November 5, 2003

RE: Amendment to Auto Storage-195 St. John Street
(ID# 2003-0218, CBL#68-A-001)

Thank you for your application for an amendment to your site plan. Upon review, the City has the following comments:

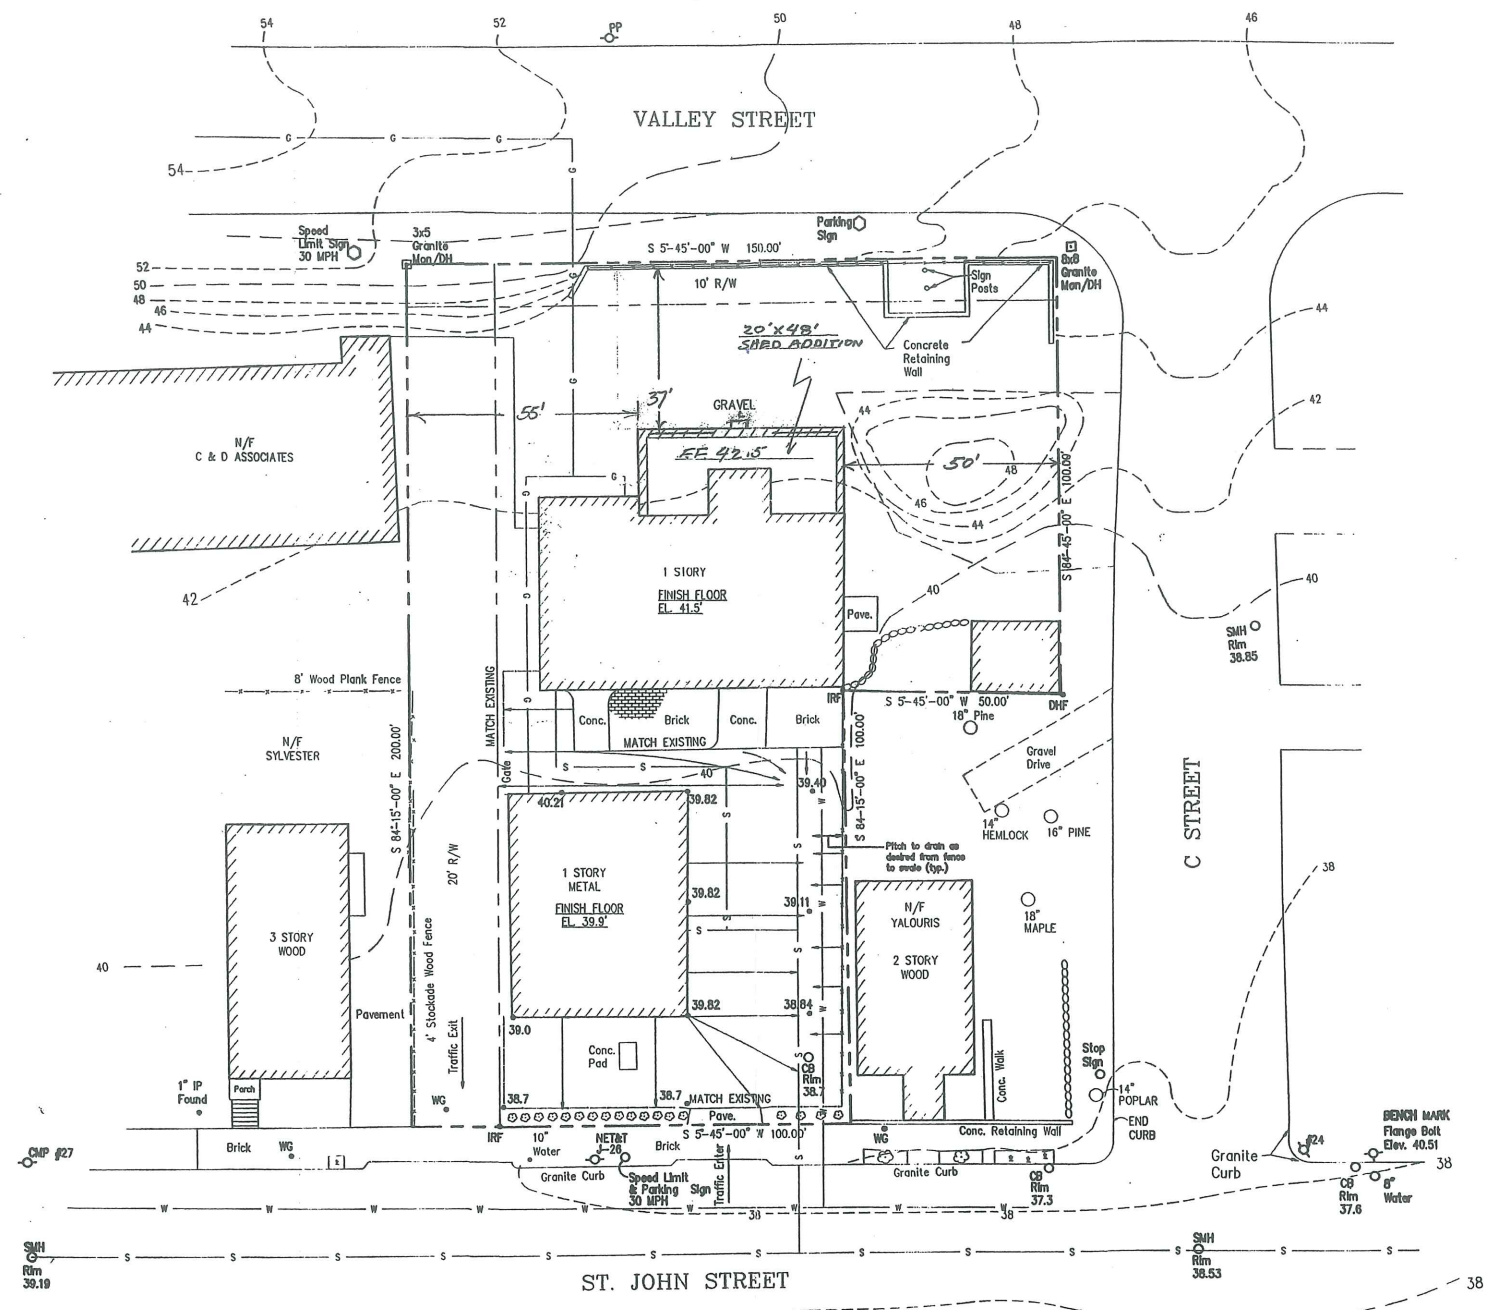
1. The location of the storage area does not appear to meet the zoning requirement with regards to setbacks (10' rear).
2. The inspections department has stated that the proposal would require a building permit.
3. It appears that the height of the vehicle storage would make these vehicles visible from Valley Street. Please provide adequate landscaping along the Valley Street right-of-way to ensure proper screening.
4. The narrative provided in your application refers to fluid leakage from these vehicles. Are there any on-site collection system(s) in place to properly manage this? Also, will the proposed pavement direct these spills to a containment system?
